Subject: RE: Planning Consultation on: WA/24/21/DOC

Condition 3- surface water drainage design

Application No: WA/24/21/DOC

Site Address: Lower Farm Yapton Lane Walberton BN18 0AS

**PERMEABLE BLOCK PAVING YARD CONSTRUCTION
WITH VOIDED SUBBASE AND FILTER DRAIN**
(Scale 1:20)

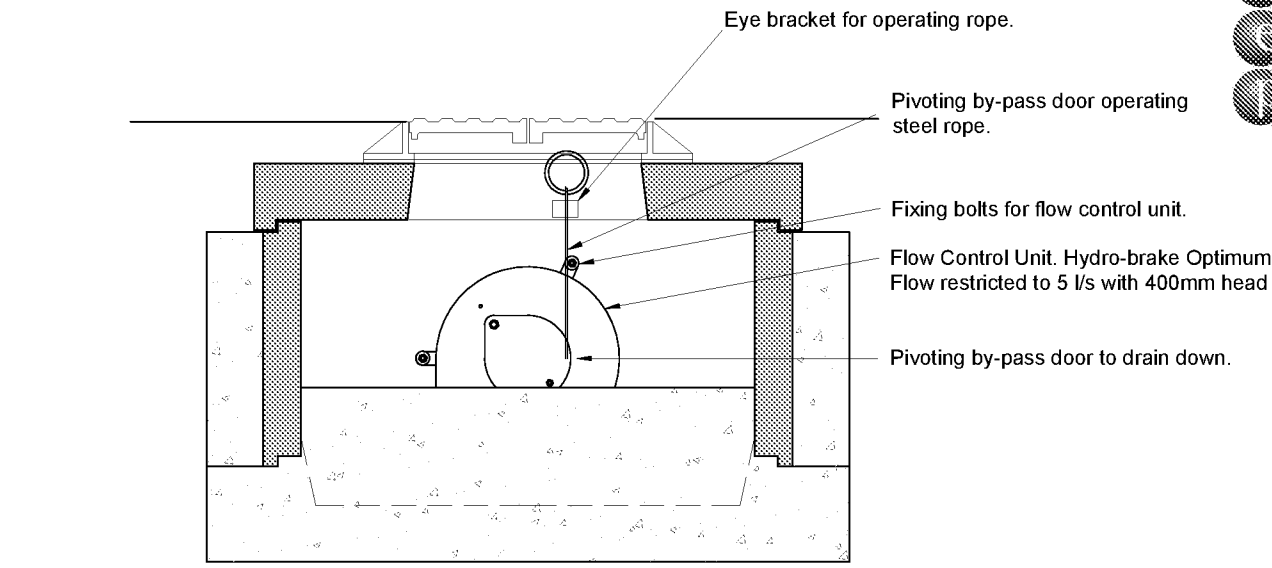
7. Finish and formation levels of permeable paving must be provided on plan.
8. Details of the proposed ditch need to be supplied, including proposed invert level, existing levels of the ditch, proposed connection invert level, long sections, cross sections.

HYDROBRAKE MANHOLE DETAIL
(Scale 1:20)

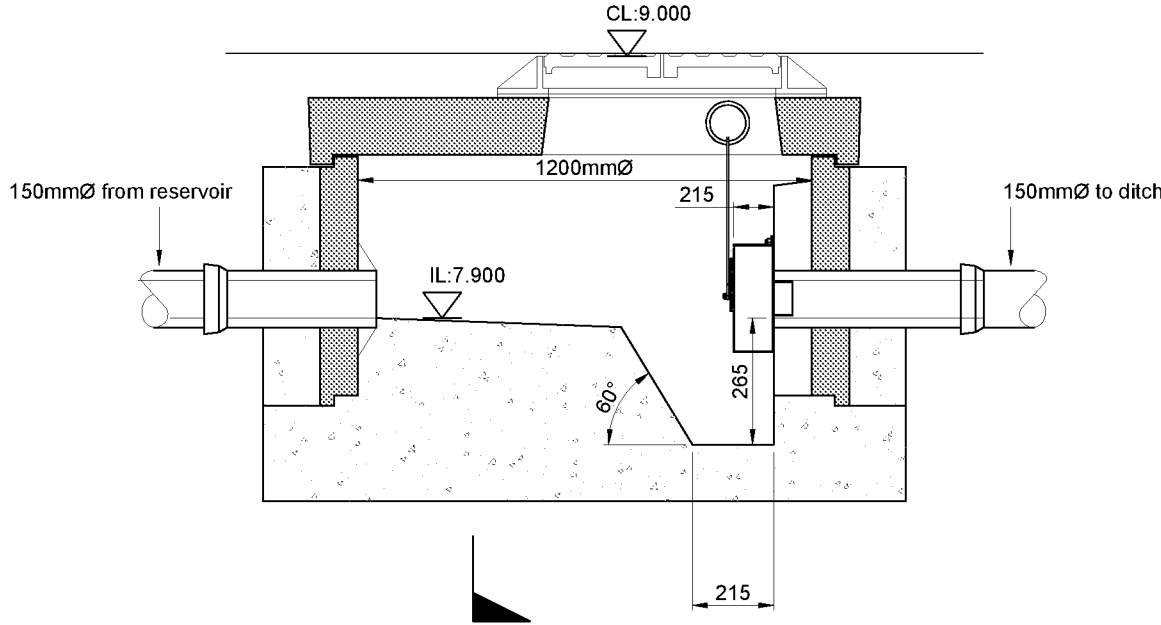
5. The construction detail of the hydrobrake needs to be updated to be consistent with layout and calculations.
6. The invert and cover level of the hydrobrake should be stated on plan.
